30 June 2016

RE: SSD 7047, Darling Harbour Live Interactive Signage Display System

I refer to State Significant Development Application SSD 7047 for signage in the Sydney International Conference, Exhibition and Entertainment Precinct at Darling Harbour.

C-08 Naming rights and event/precinct information

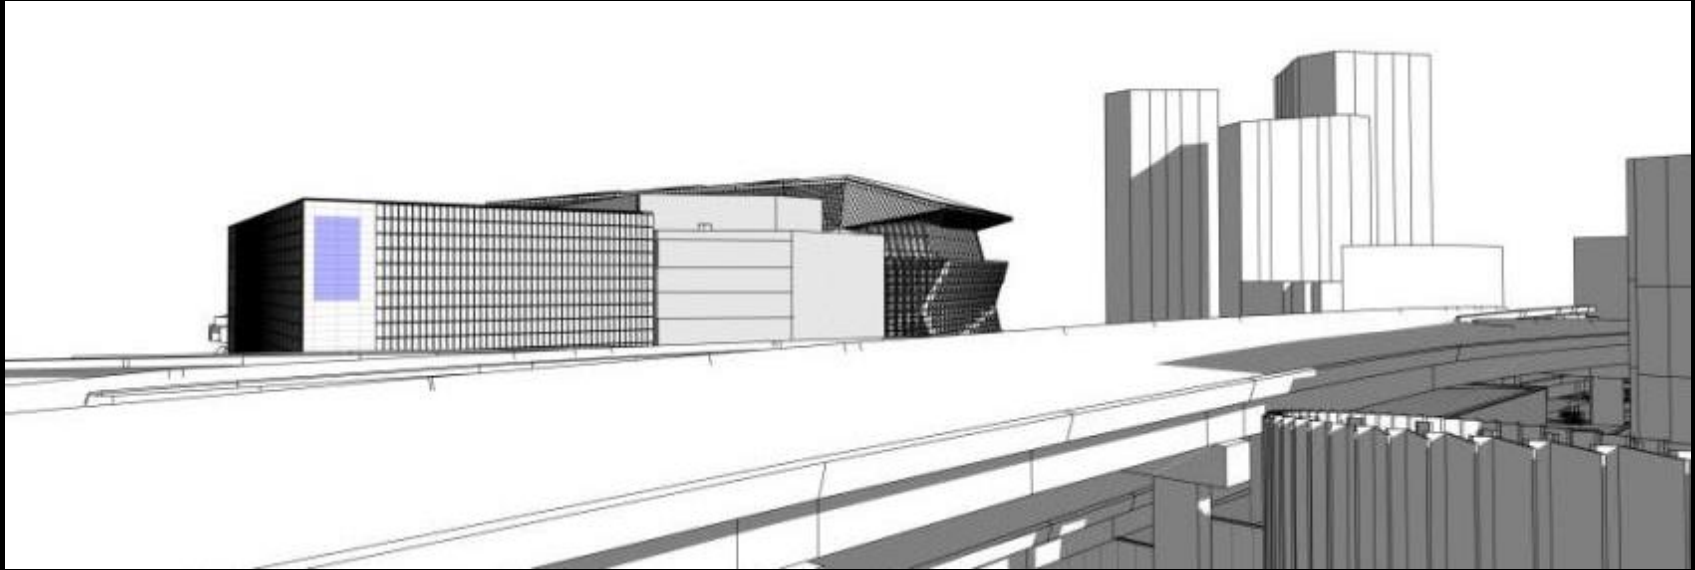
The Visual Impact Assessment submitted with the application includes a LED billboard sign proposed at the southern elevation of the Convention Centre to face the Western Distributor overpass. However, there is no reference to the sign in the Development Overview of the SEE (Ref. to Table 3 on page 26). The applicant should clarify if approval for the subject sign is sought as part of the current application.

T-01 Dynamic Projection – Birdsmouth (continued)

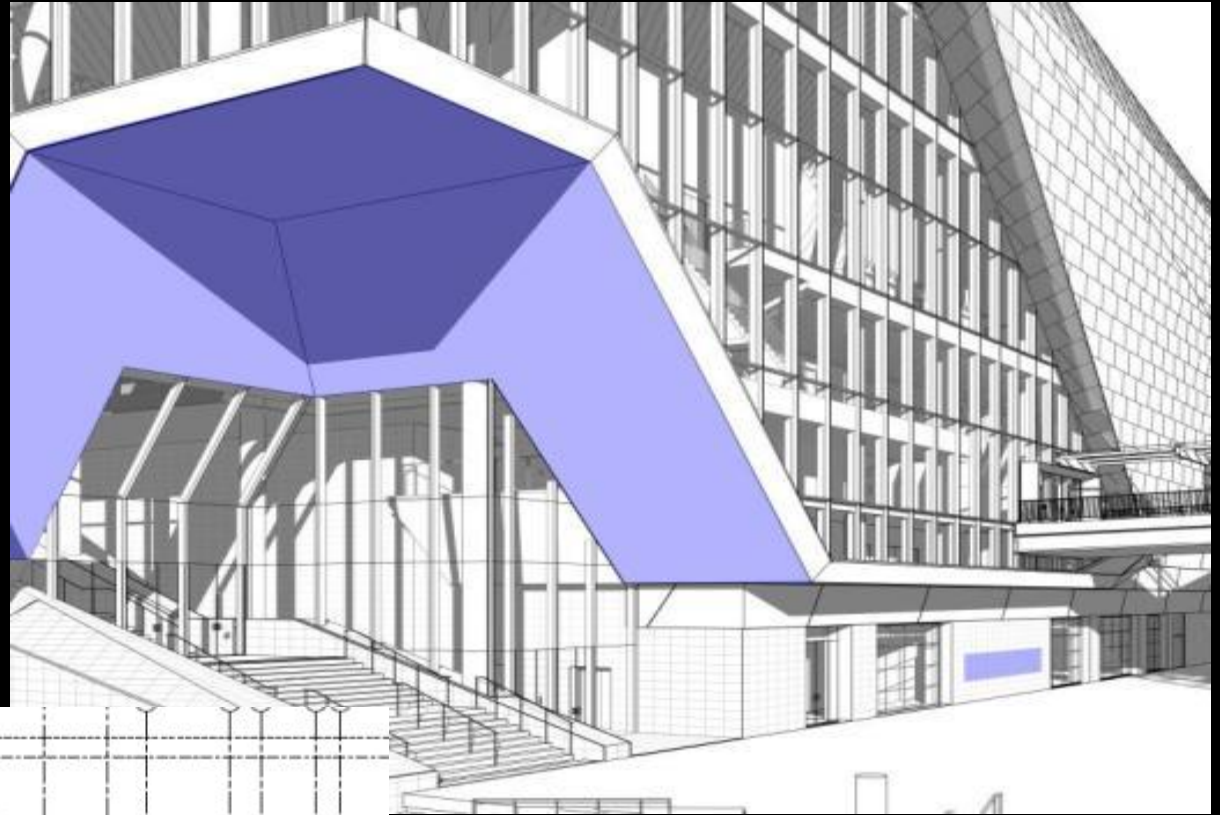
The City objects to these signs being used for third party advertising, as is currently proposed, for the reasons outlined above.

T09 - Naming rights and event/precinct information

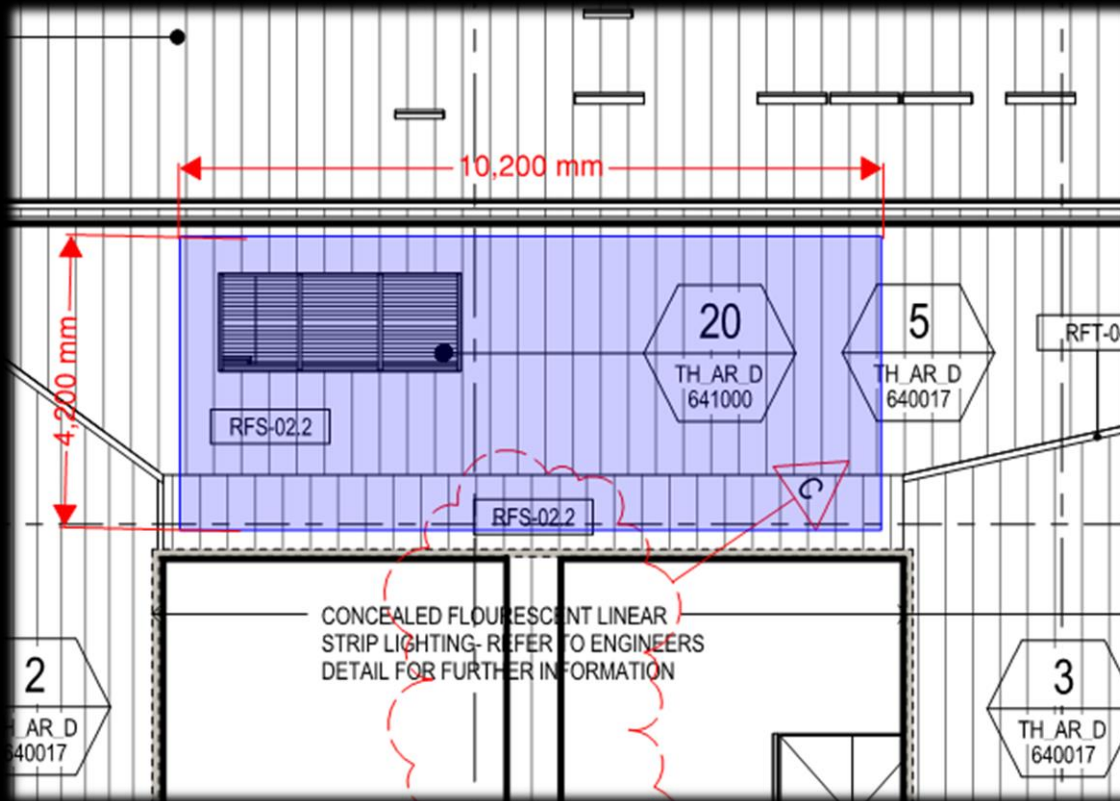
T-09 is a 38.4m² digital LED screen that will be used solely for building identification. It is located on the southern face of the Theatre and is identified as a Building Identification Sign. The sign will be visible from the Pier Street overpass and possibly from buildings within the city centre and from streets within the City.

The view analysis is inadequate to determine its impact from the CBD, and it is recommended that further analysis be undertaken.

In addition, the City is of the view that it is illogical to utilise a LED sign of this size for the sole purpose of building identification, and it is realistic to assume this sign will be used for third party advertising. Furthermore, the submitted documentation provides no detail regarding the content of the sign as would ordinarily be expected for a sign of this nature.

In light of the above, the City is very concerned that the long term objective for this sign is for third party advertising. Billboard signs are generally not permitted in the City of Sydney LGA by Section 3.16.17 of the Sydney DCP 2012 and are not supported.

It is recommended that the applicant provide additional information regarding this sign, including the rationale for selecting an LED sign of this size and further information regarding the proposed content. If the purpose of the sign is genuinely for building identification, it is the City's view that a design similar to Building Identification Signs proposed elsewhere in the precinct would be more suitable.

T-17 Naming rights and event/precinct information

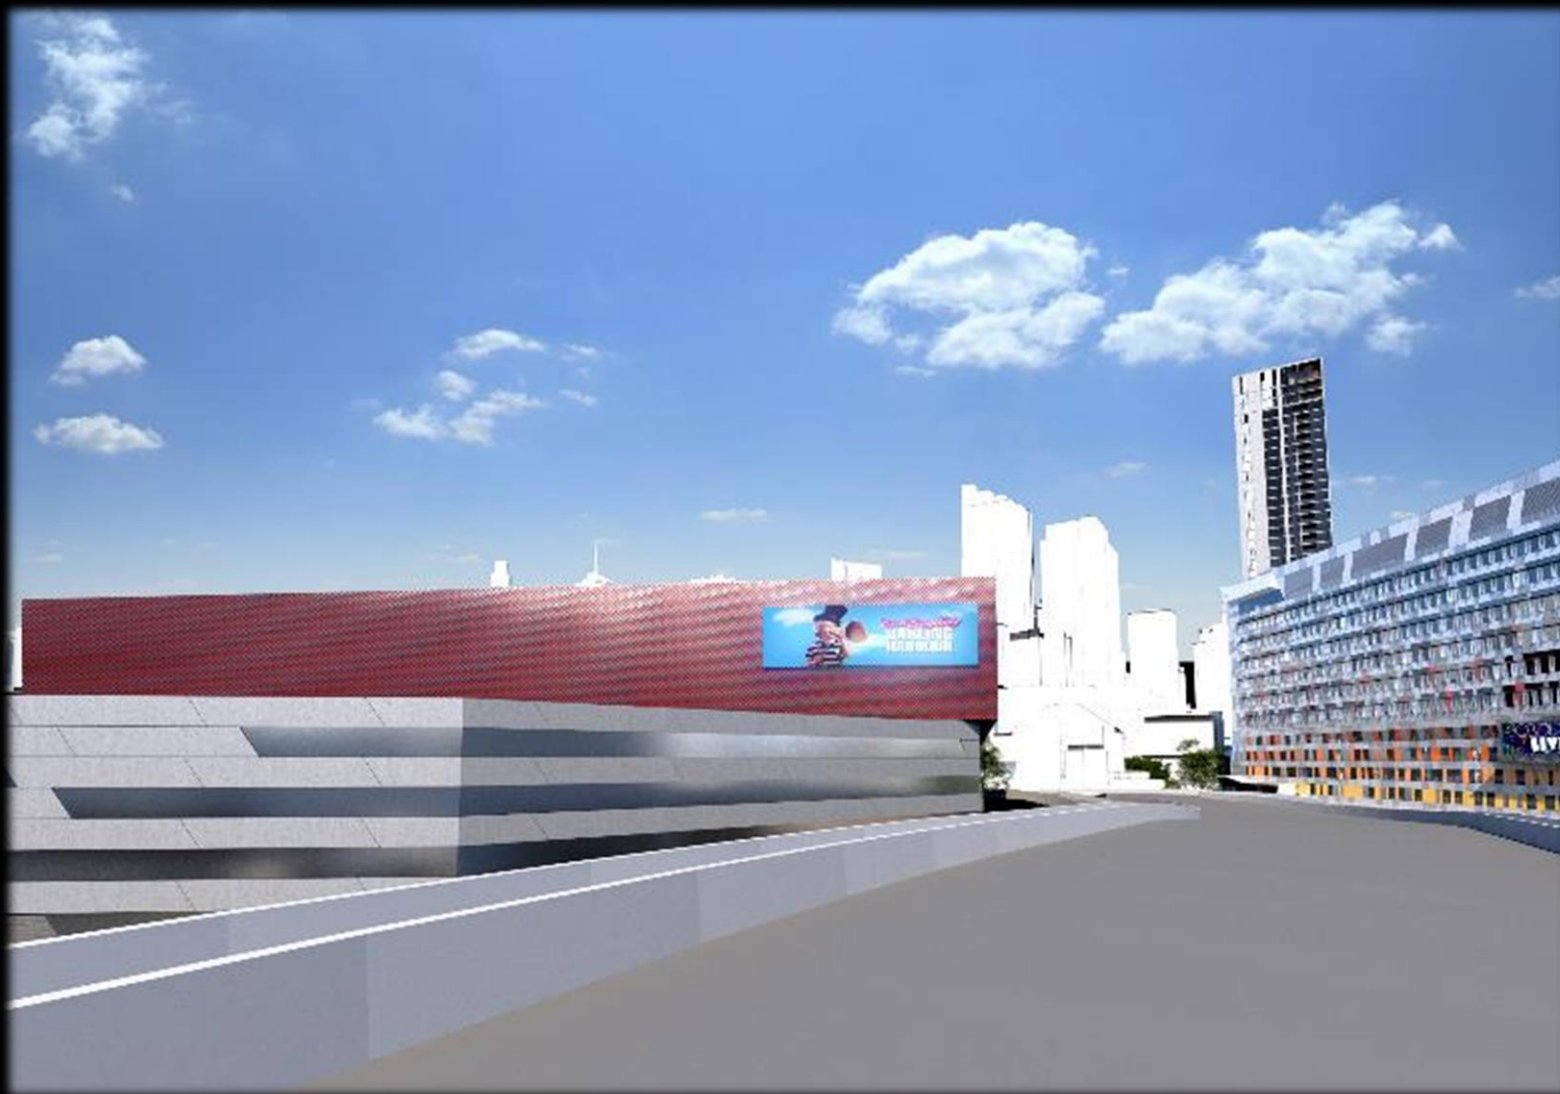
T-17 is a 84m² digital LED screen that is located on the western face of the Theatre that will be used to advertise current and upcoming events at the Theatre, and for third party 'precinct partner' advertising.

The view analysis is inadequate to determine its impact from the CBD, and it is recommended that further analysis be undertaken in relation to light spill, glare and driver distraction to vehicles on roads.

The location of the sign and its size maximises its visibility from the Pier Street overpass. The City has concerns regarding vehicular safety, as there is the risk that the sign will materially divert a driver's attention leading to an increased risk of collisions at this busy city thoroughfare. In this respect, concurrence from the RMS is paramount.

Furthermore, the proposed location of the sign appears to be contrary to the Court's findings in "*oOh! Media Assets Pty Ltd v The Council of the City of Sydney and Anor* [2015] NSWLEC 1269" relating to impacts of commercial billboards on vehicular safety.
